REQUEST

Current Zoning: MUDD-O/I-2 (mixed-use development, optional & industrial)
Proposed Zoning: MUDD-O and MUDD-O SPA (mixed-use development, optional and mixed-use development, optional, site plan amendment)

Approximately 0.7 acres located SW of the intersection of Belmont Avenue and Seigle Avenue in the Belmont neighborhood.

The petition proposes a rezoning/site plan amendment that would allow for an existing building to be repurposed and permit up to 15,000 SF (10,500 SF in addition to existing building footprint) of limited non-residential uses permitted within the MUDD district.

# RZ-1.0

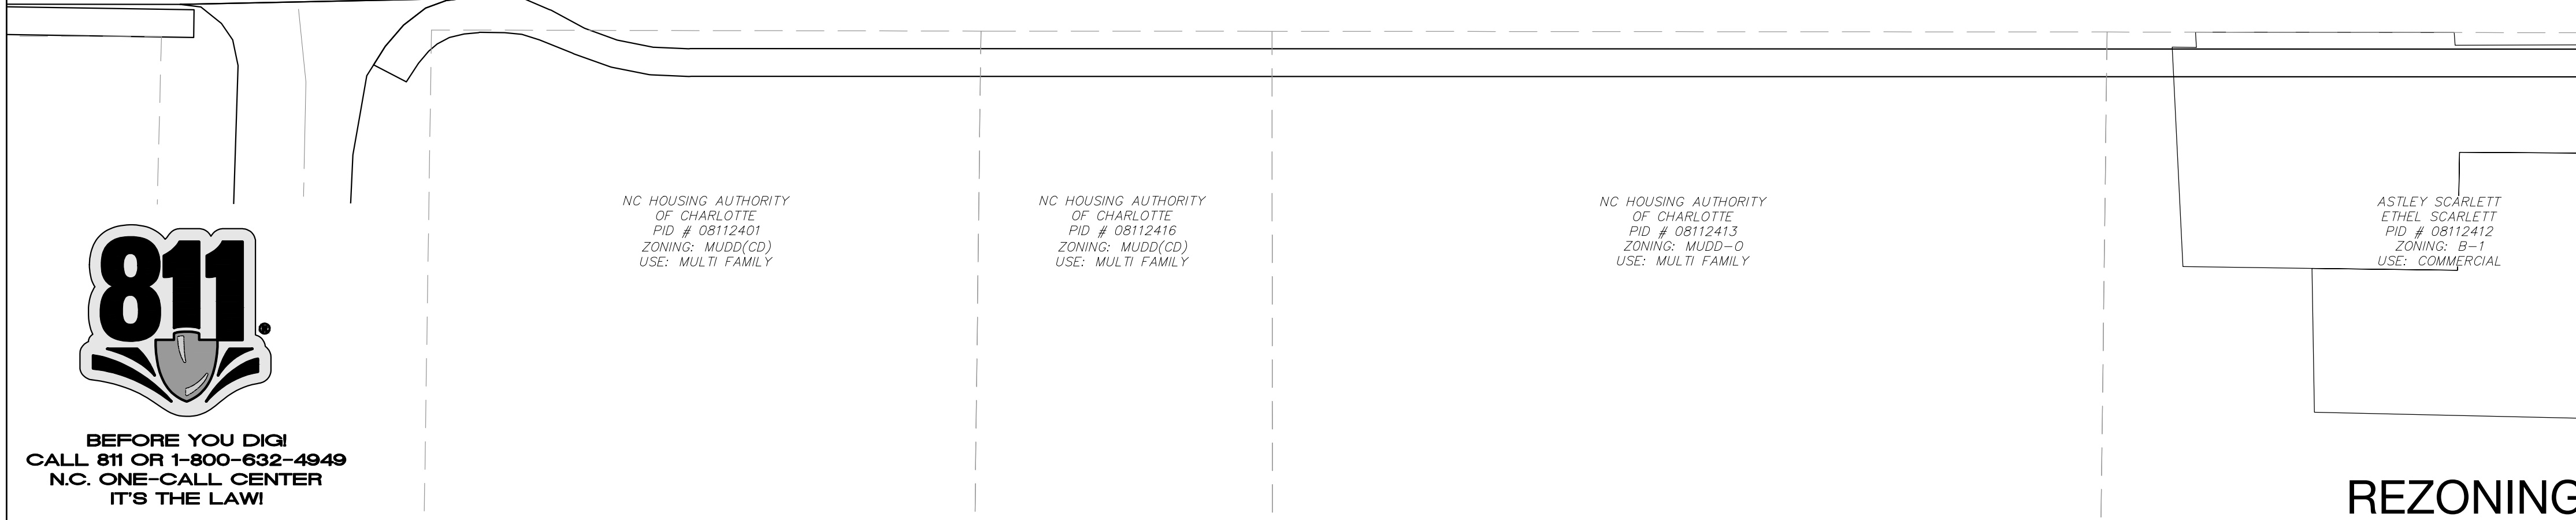
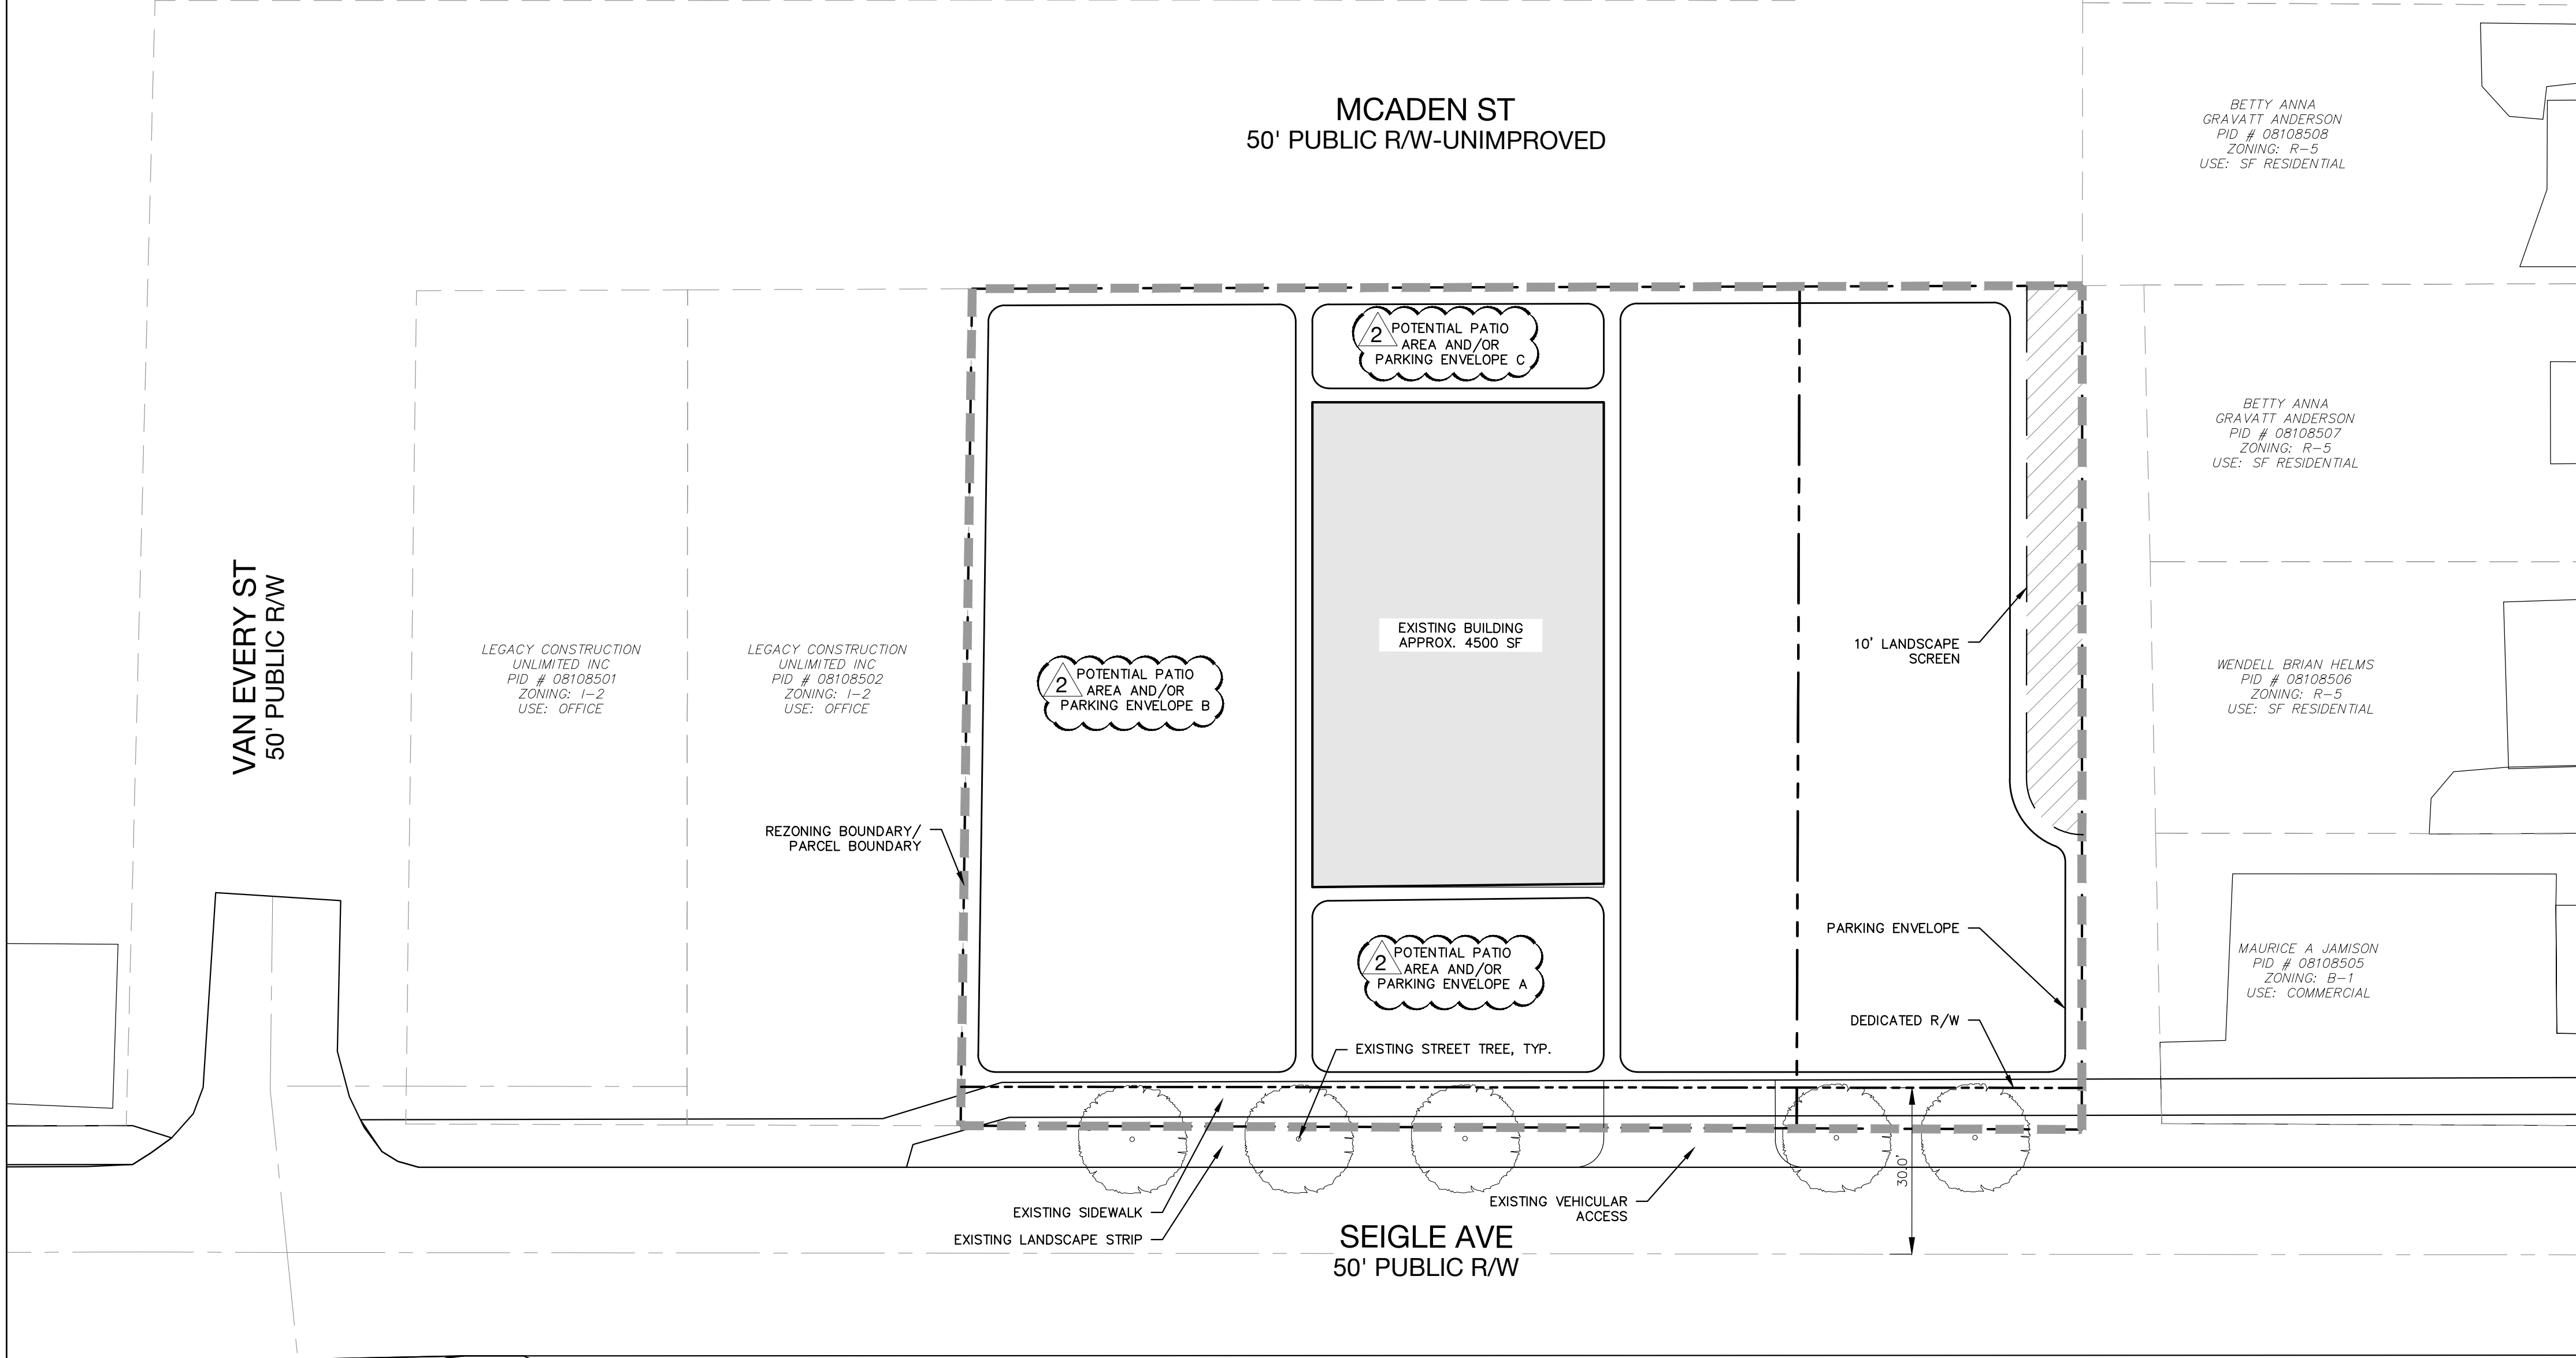
3. Please illustrate building envelopes for potential building expansion listed in conditional notes. This approach could be utilized to clarify the requested technical revision (9) below. **ADDRESSED**

4. Remove parking provision in Transportation section (note 2). Shall be provided per ordinance. **ADDRESSED**
5. Illustrate screening in areas outlined in site plan staff comments along the eastern and western property boundary. **ADDRESSED**

6. Amend the minimum height of the proposed green screen to 4 feet in height; provide detail of green screen. **ADDRESSED**
7. Please clarify that parking will comply with ordinance requirements and parking shall not be permitted between the street and any additional buildings/additions/improvements made to the site. Staff is comfortable only with permitting parking between the street and the existing building. **RESCINDED**

8. Adjust site development table to reflect parking required per ordinance and proposed building area up to 15,000 SF. **ADDRESSED**
9. Please clarify/reword notes 3 & 4 in optional provisions to more clearly reflect the provisions being asked for patio/parking areas. This revision should also note or cross-reference the above outstanding issue 7 regarding the location of parking in front of any future improvements/additions. **ADDRESSED**
10. As parking is not permitted within potential patio area and/or parking envelope A, please remove reference to parking in that area. **ADDRESSED**
